From: Steven King [REDACTED]
Sent: 10 October 2022 13:28
To: Connor Smalls [REDACTED]
Subject: Re: 22/01559/F The Maltings, Tower Road, Burnham Overy Staithe.

Drawing: New first floor plan
Scale: 1:100 @ A4

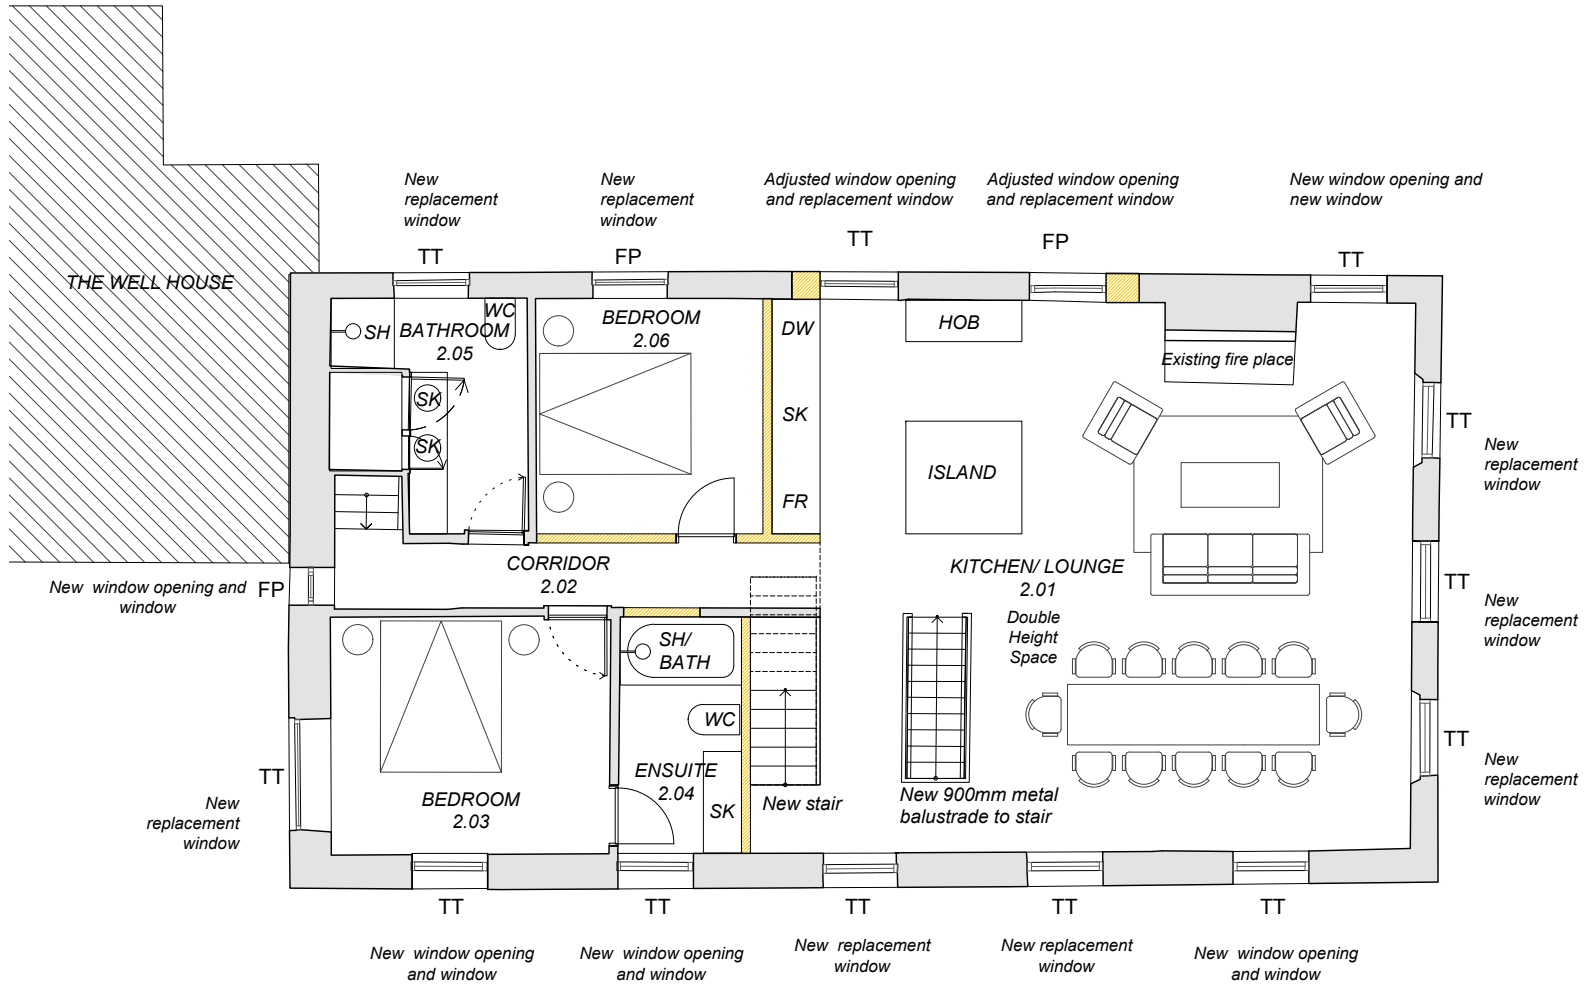
Window treatment to north and west elevations
Given the existing treatment well designed aluminium windows may be acceptable. However, I am still not convinced by the window styles to the north and west elevations. In the current form the windows look blank and featureless, unlike other windows in the locality. Some introduction of glazing bar would help along with more confirmation that the windows are to be recessed within the masonry.
